Re: 131, 139, Parkdale Ave and 128 Forward Ave – Urban Design Review Panel Recommendation

On January 9th, 2026 at 9:00am we presented our proposal for a new development located at 131, 139 Parkdale Ave, and 128 Forward Ave. on behalf of our client 11034936 Canada Inc. (Brigil). Included below are our responses to the recommendations made by the City of Ottawa Urban Design Review Panel, dated January 9th, 2026.

Re: 131 Parkdale Avenue - UDRP Comment Response to Landscape Items

LEVEL 01 FLOOR PLAN

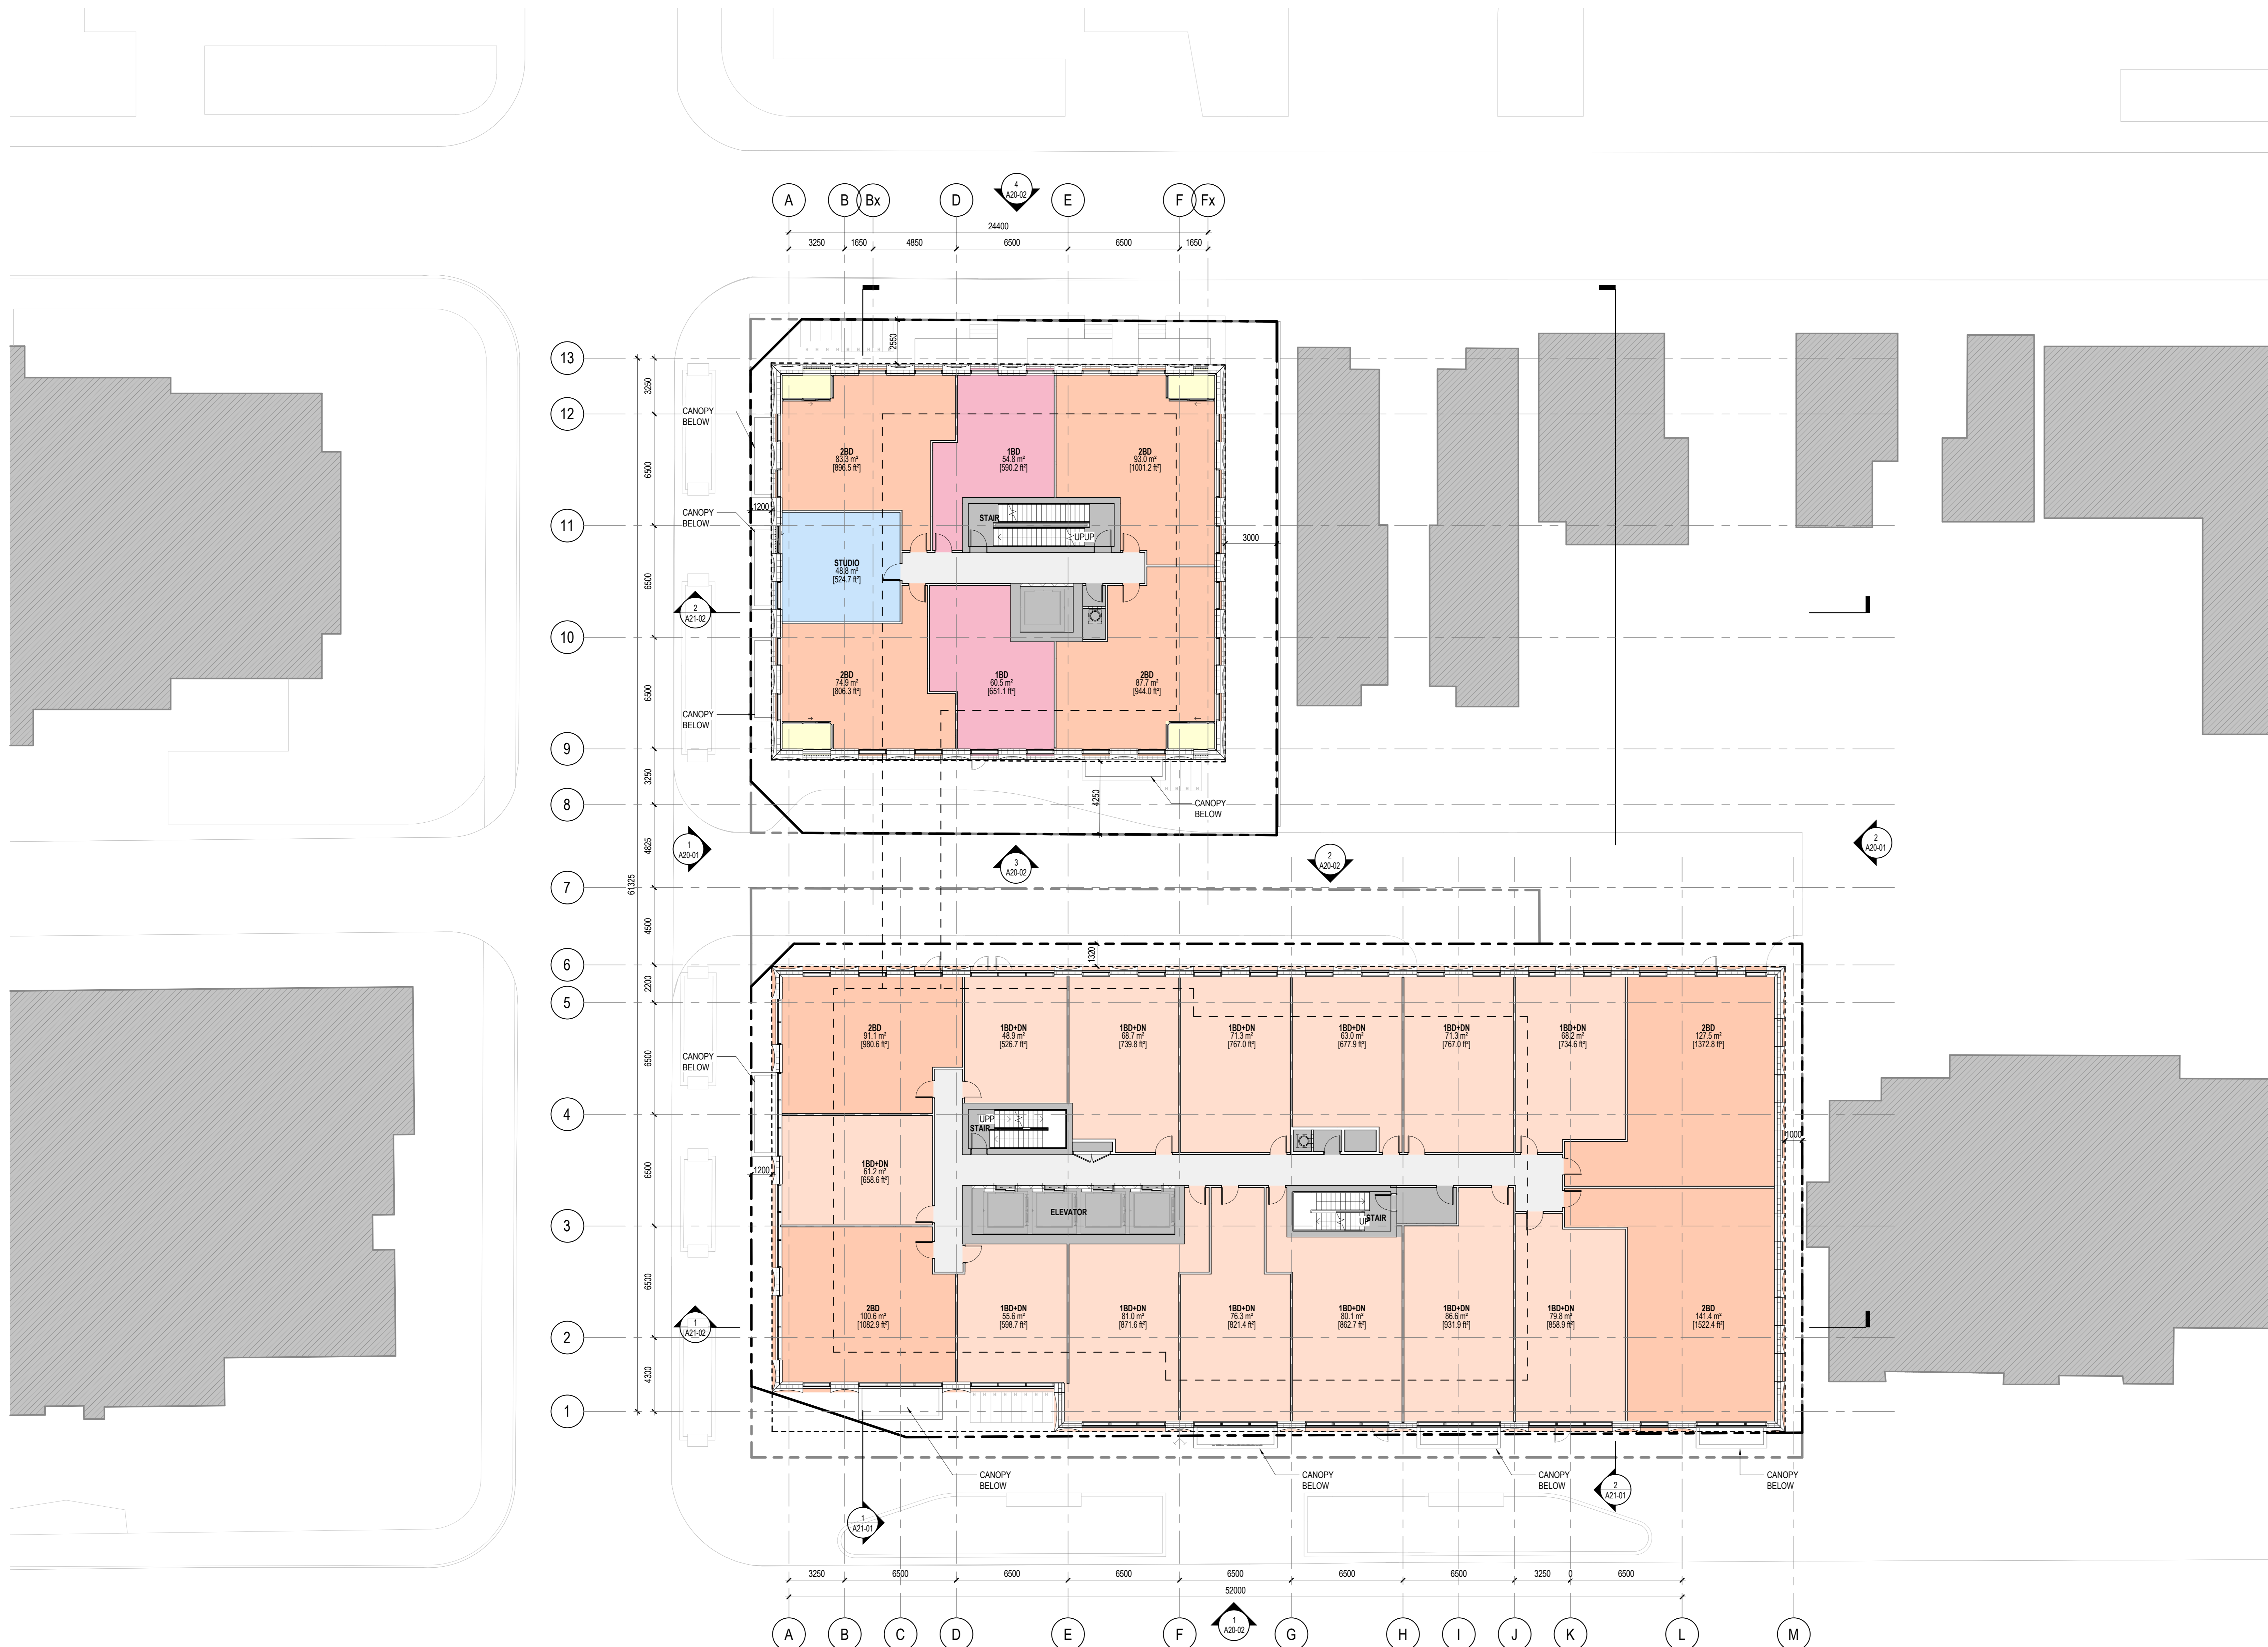
<p>The Panel expressed some concern that part of the passageway may be need for vehicular maneuvering.</p>	<p>The passageway has been removed. Vehicle movements will take place within the laneway only.</p>
<p>Sustainability</p>	
<p>The Panel encourages a strengthened sustainability agenda across the site, integrating building and landscape strategies that address climate, resilience, and long-term durability.</p> <p><i>Opportunities include incorporating green infrastructure within planters to manage stormwater, prioritizing low-embodied-carbon materials from local suppliers, and carefully selecting planting to ensure resilience to winter conditions.</i></p> <p><i>The Panel also supports subtle design integration of building motifs, such as scallops, into landscape elements to reinforce cohesion between architecture and public realm.</i></p>	<p>Please see attached memo from the Landscape Architect for sustainability strategies utilized within the landscape.</p> <p>As the project develops, we will also explore ways to tie the site design and building architecture together such as by using similar colours on metal elements in the podium and the landscape and incorporating scallops into concrete planters.</p>
